From: Sarah Burrow <Sarah.Burrow@arun.gov.uk>
Sent: 04 October 2021 10:58
To: Planning.Responses <Planning.Responses@arun.gov.uk>
Cc: Richard Sherman <Richard.Sherman@arun.gov.uk>
Subject: RE: Planning Consultation on: BN/113/21/HH

Engineers Comments Regarding Surface Water Drainage

Application No: BN/113/21/HH
Registered: 24th August 2021
Site Address: 26 Gospond Road Barnham PO22 0EU
Grid Reference: 495564 104449
Description of Works: Erection of single storey side extension and loft conversion with 1 x rear dormer following the demolition of existing single storey front and side extensions

BLOCK PLAN 1:200

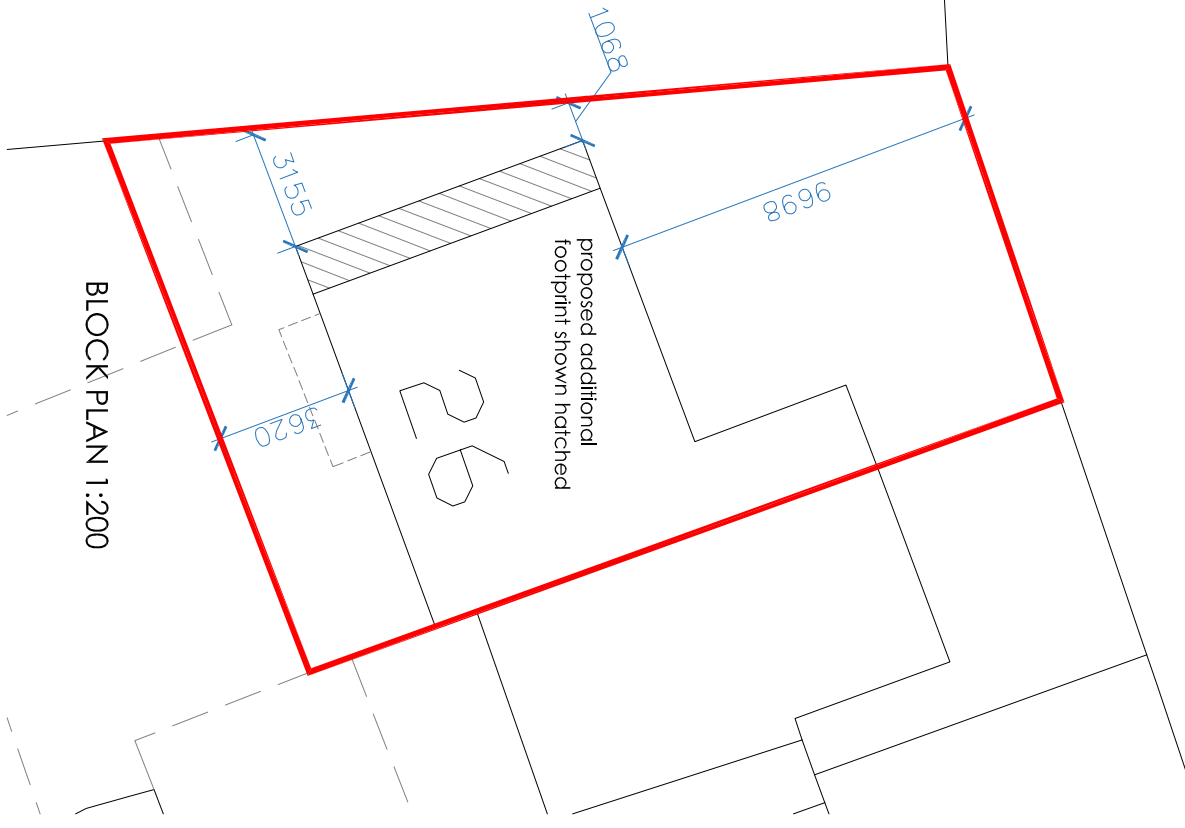
The application is within the Lidsey Treatment Catchment, therefore surface water drainage design should be carefully considered. Infiltration must be fully investigated.

The applicant is to be made aware that our mapping indicate a foul water sewer running through the rear garden of the property.

"Development shall not commence, other than works of site survey and investigation, until full details of the proposed surface water drainage scheme have been submitted to and approved in writing by the Local Planning Authority. The design should follow the hierarchy of preference for different types of surface water drainage disposal systems as set out in Approved Document H of the Building Regulations, and the recommendations of the SuDS Manual produced by CIRIA. Winter groundwater monitoring to establish highest annual ground water levels and winter Percolation testing to BRE 365, or similar approved, will be required to support the design of any Infiltration drainage. No building / No part of the extended building shall be occupied until the complete surface water drainage

system serving the property has been implemented in accordance with the agreed details and the details so agreed shall be maintained in good working order in perpetuity."
